HCI ENGINEERING

March 3, 2017

Re: Responses to Conditions of Approval – Dated November 14, 2016

Project: HCI 15-39 Taco Bell at Heritage Marketplace

**A1.1**

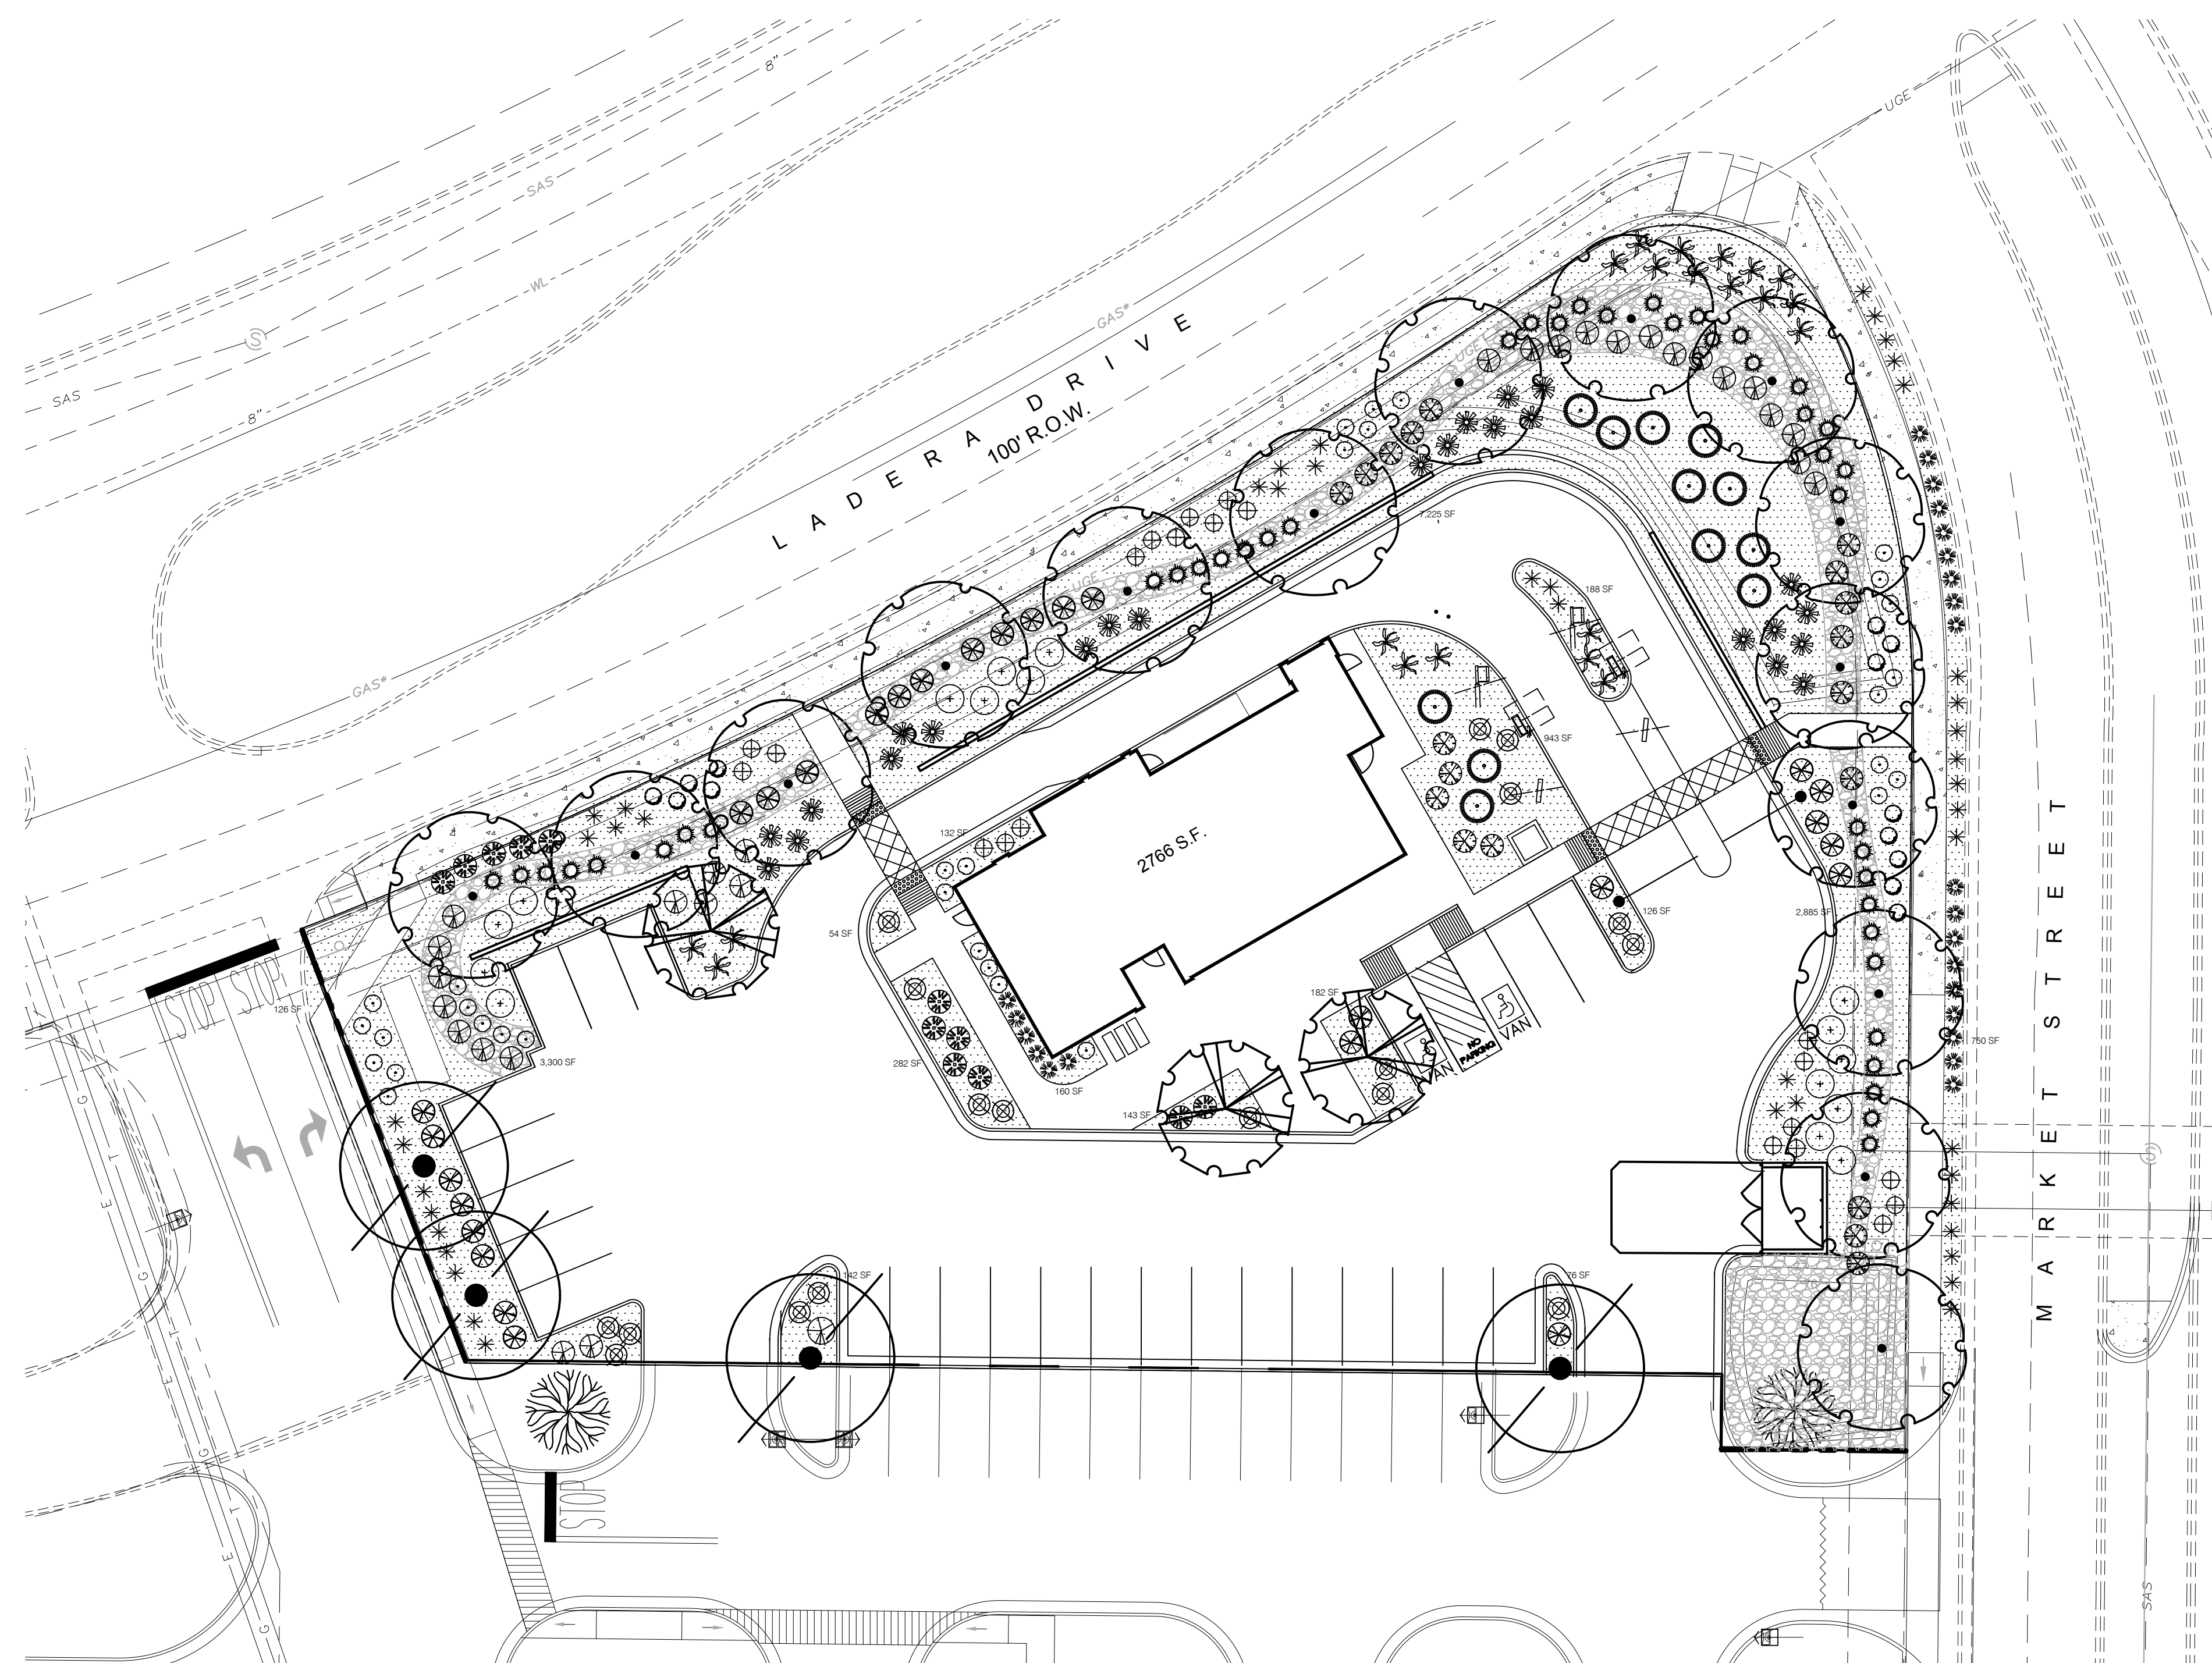
- a. Minimum drive thru lane width is 12 feet with a 25 foot minimu radius (inside edge) for all turns

- b. The ADA access aisles shall have the words “NO PARKING” in capital letters, each of which shall be at least one foot high and at least two inches wide, placed at the rear of the parking space so as the be close to where an adjacent vehicle’s rear tire would be placed. (66-1-4.1.B NMSA 1978).

- c. The ADA accessible parking sign must have the required language per 66-7-352.4C NMSA 1978 “Violators Are Subject to a Fine and/or Towing.” Please call out detail and location of HC Signs.

- d. Define the Radii on all curbs especially drive thru lane.

- e. Identify the right of way width, medians, curb cuts, street widths and street names.

- a. Northern entrance appears to have a diagonal curb at entrance, creating a hindrance for truck access. Please remove curb and keep entrance dimensions at 27.14'. Move proposed refuse enclosure 2' to the North for truck access. Do Not plant anything next to proposed refuse enclosure that will create an overhang. All new/proposed refuse enclosures must be built to COA minimum spec. requirements, need complete/detailed spec. sheet for proposed refuse enclosure, including a sanitary drain.

Response: The curb radii and lane width meet these criteria.

Response: Markings have been placed on the plans with a note referring to code 66-1-4.1.B NMSA 1978.

Response: The detail has been updated and location of the signs called out on the Site Plan.

Response: All radii have been defined.

Response: The right of way width, medians, curb cuts, street widths and street names have been identified.

Response: This curb line was an error. The area is a concrete pan, and the back of curb line has been removed. The trash enclosure has been moved 2' to the north. No plantings resulting in overhang will be proposed. A detailed spec sheet will be submitted separately.

1 South Elevation

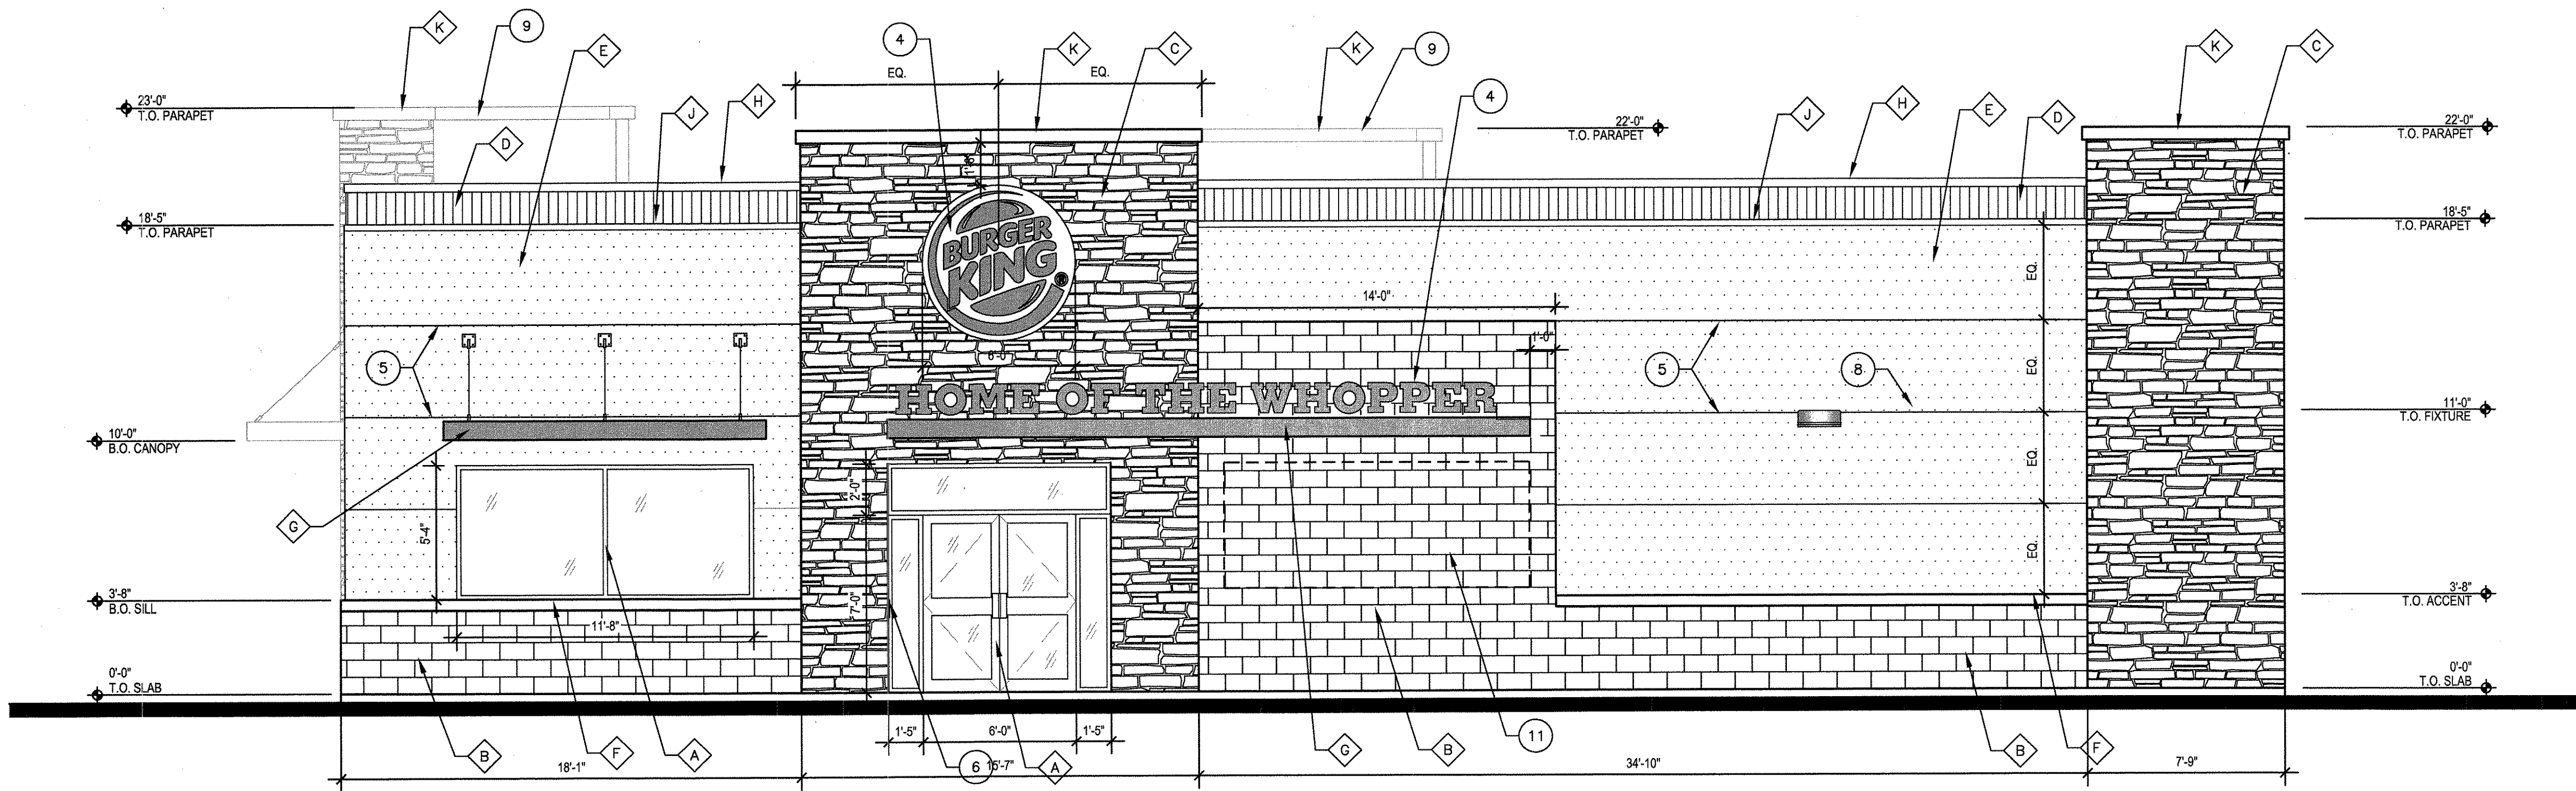
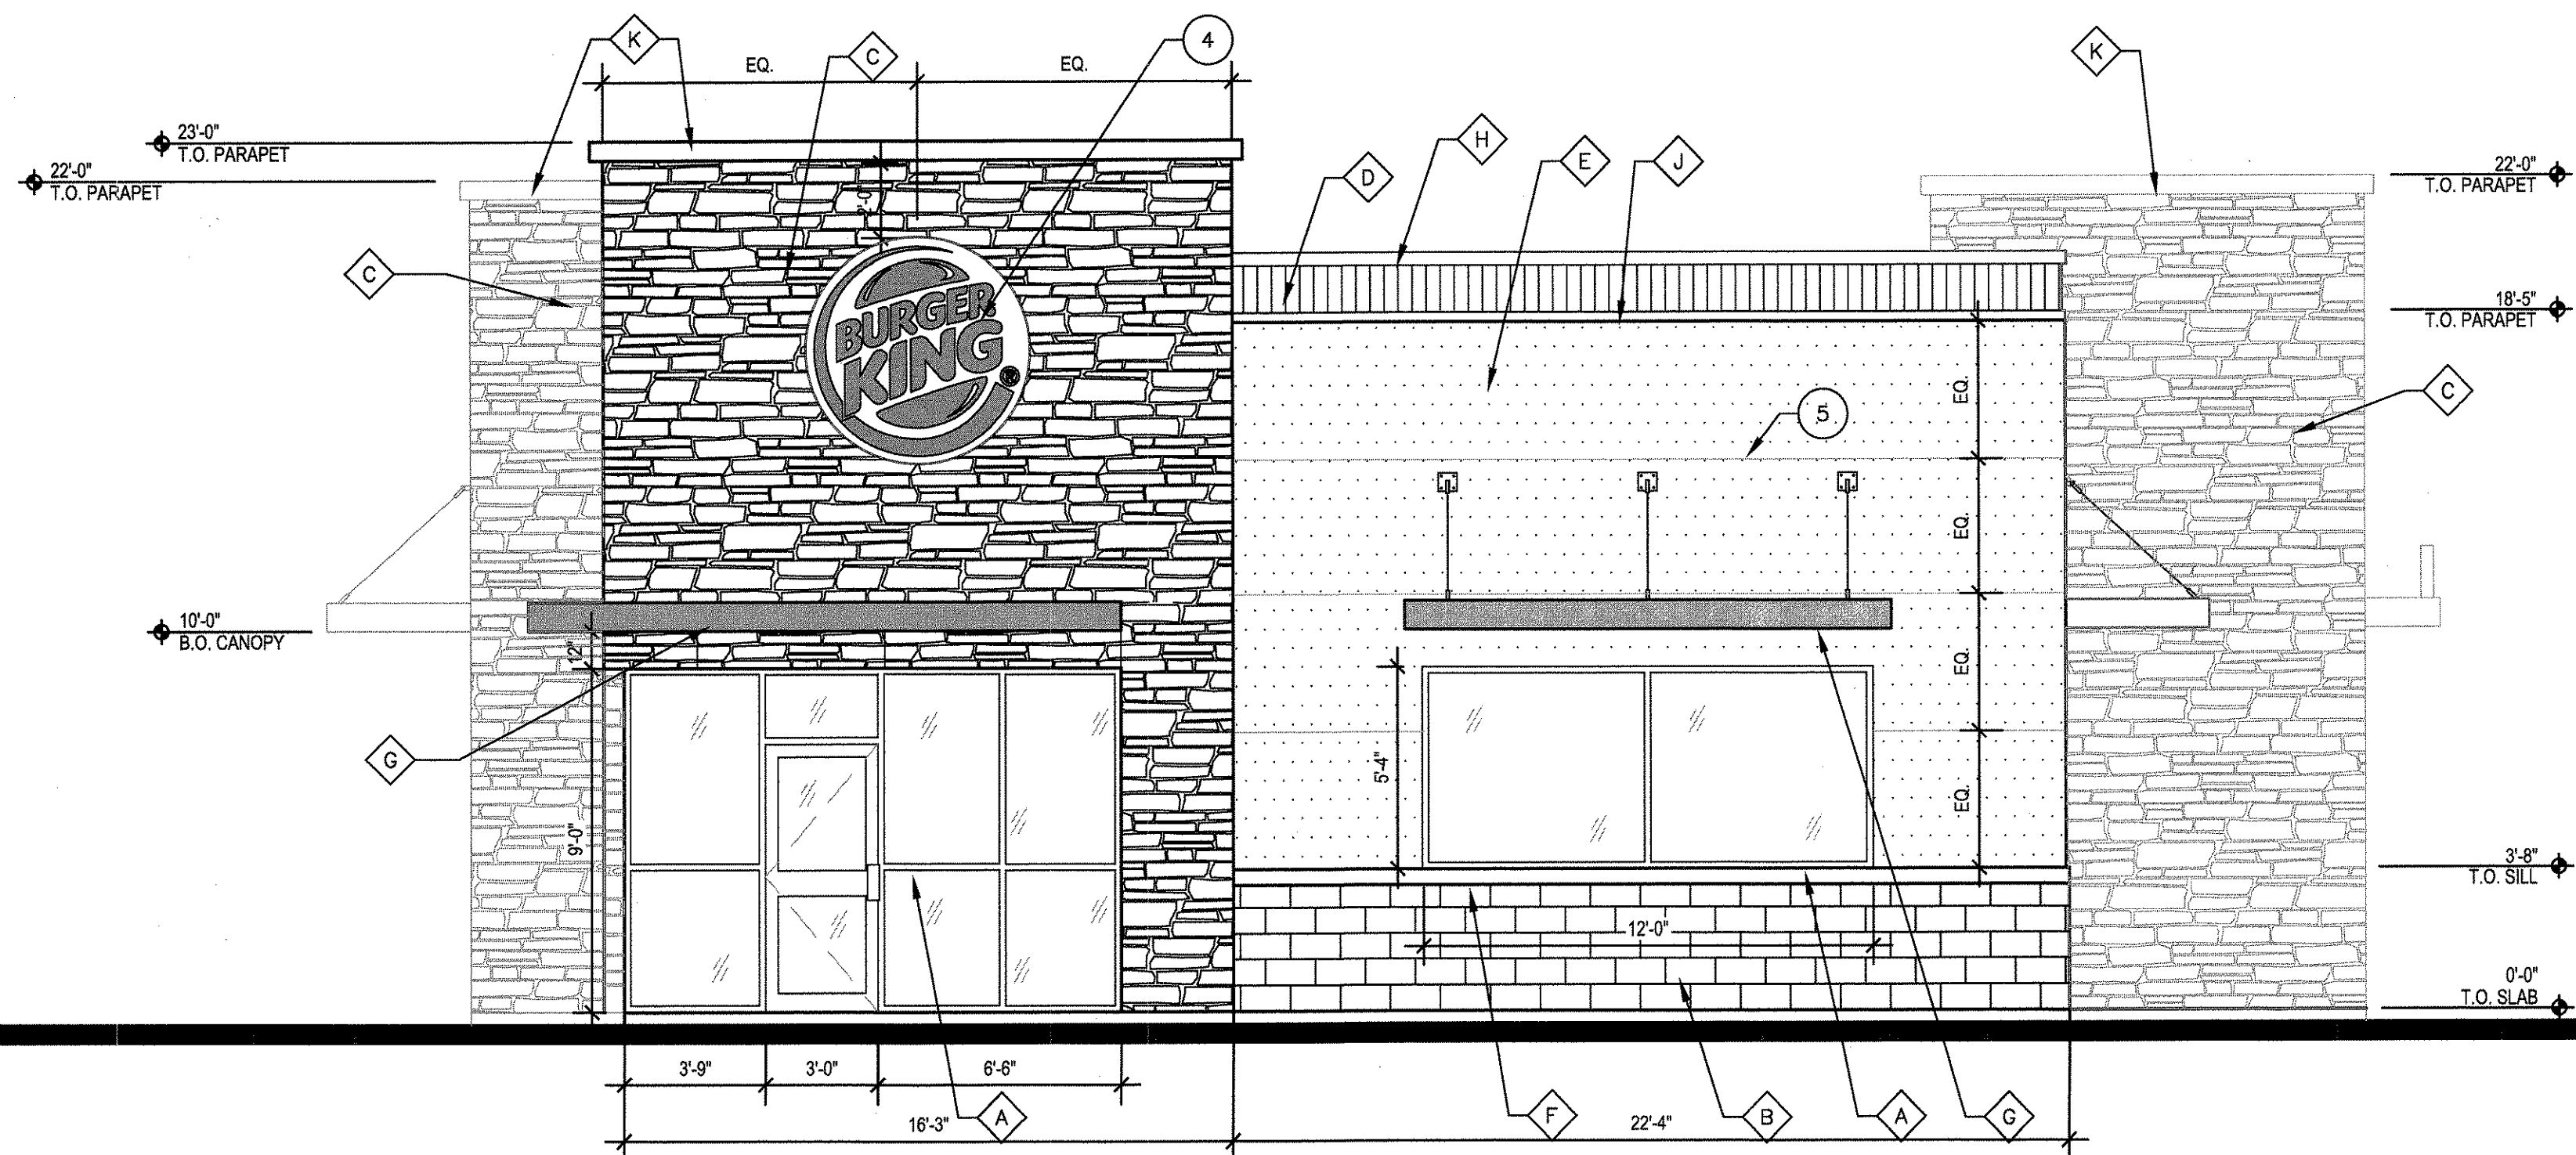
Response: The note has been added.
4. The exterior building elevations contained on Sheets A4.0 and A4.1 currently identifies the elevations according to right, left, front and rear side. Thee elevation shall be modified to read east, west, north and south elevations.

Response: The elevations have been labeled as east, west, north and south accordingly.
